PLANNING CONSULTATION RESPONSE

Application No	2025/0532
Proposal	Conversion of vacant church and church hall; installation of first floor in church building and associated works to create 11 residential apartments (Use Class C3).
Address	Wesleyan Reform Church, Wakefield Road, Smithies, Barnsley, S71 1NP
Date of Consultation Reply	17/07/2025
Consultee	Charlie Atkinson Design and Conservation Apprentice

Project	Proposed Change of Use of Existing Church to 11 No Apartments at 175 Wakefield Road, Smithies, Barnsley S71 1NP for Mr G Singh	Date 08/05/2025
Drawing	Proposed Elevations & Roof plan for Building B	A1
		2562
		R
		Scale
		1:100
	Drg No	2

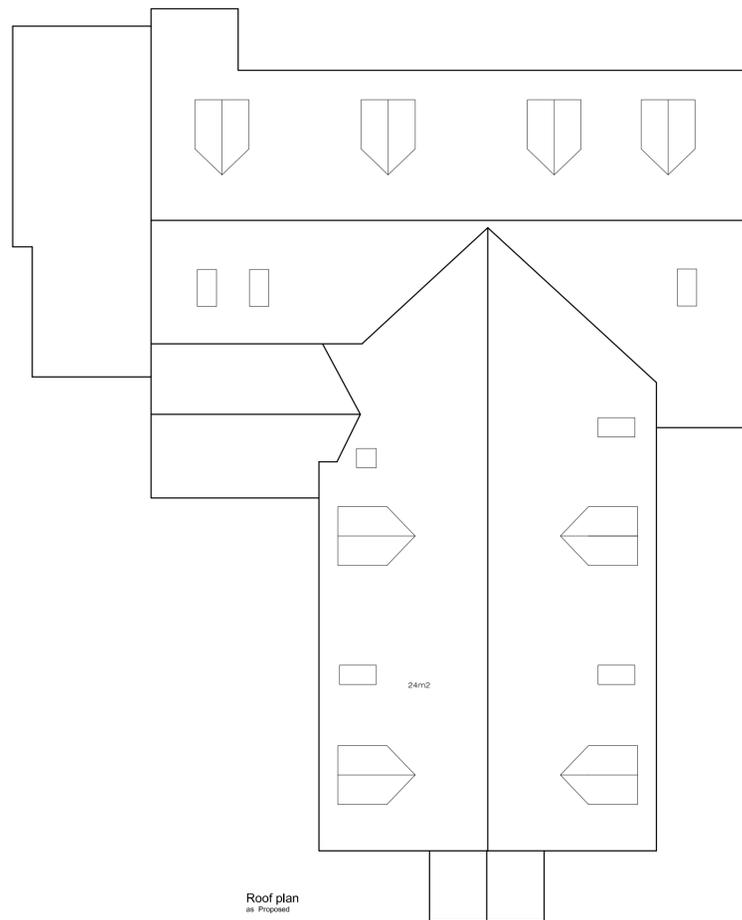
The proposal appears to have minimal impact on the external envelope of the building, thereby maintaining its architectural and historical character. However, while the overall external appearance may largely remain unchanged, the proposed alterations include the addition of eight new dormer windows, seven rooflights, a side access ramp, and the replacement of one window on the north elevation to provide emergency access. It is recommended that conservation rooflights be used throughout the development. We suggest that the four dormer windows visible from Wakefield Road be removed to preserve the building's historic appearance and architectural integrity. These could instead be replaced with conservation rooflights to achieve the similar functionality while maintaining the building's character. For the dormer windows proposed to the rear of the church, we recommend that they be clad in timber or lead, finished in an anthracite colour, rather than using PVC. This would ensure a more sympathetic and complementary appearance in keeping with the building's historic fabric. Regarding the windows throughout the building, it is evident that many have been broken (possibly due to antisocial behaviour) and will therefore require either repair or replacement. Any replacement windows should replicate the original profiles to maintain the building's character, and where stained glass is present, such as on the south elevation, secondary glazing should be installed to improve thermal performance without removing the original glazing. On site, a wire mesh has been installed in front of the stained-glass window to protect it from damage; we recommend that this be retained or similarly replaced to continue safeguarding the stained glass. To further enhance the building's energy performance, we advise that any new double-glazed units be of a slim profile to reflect the period character of the building.

- The removal of the four dormer windows visible from Wakefield Road
- The proposed cladding material for the rear dormers
- The profile and detailing of replacement windows
- The approach to secondary glazing, particularly in relation to stained-glass windows
- The design and treatment of external doors
- The retention and position of interior roof beams
- The installation of the first floor.
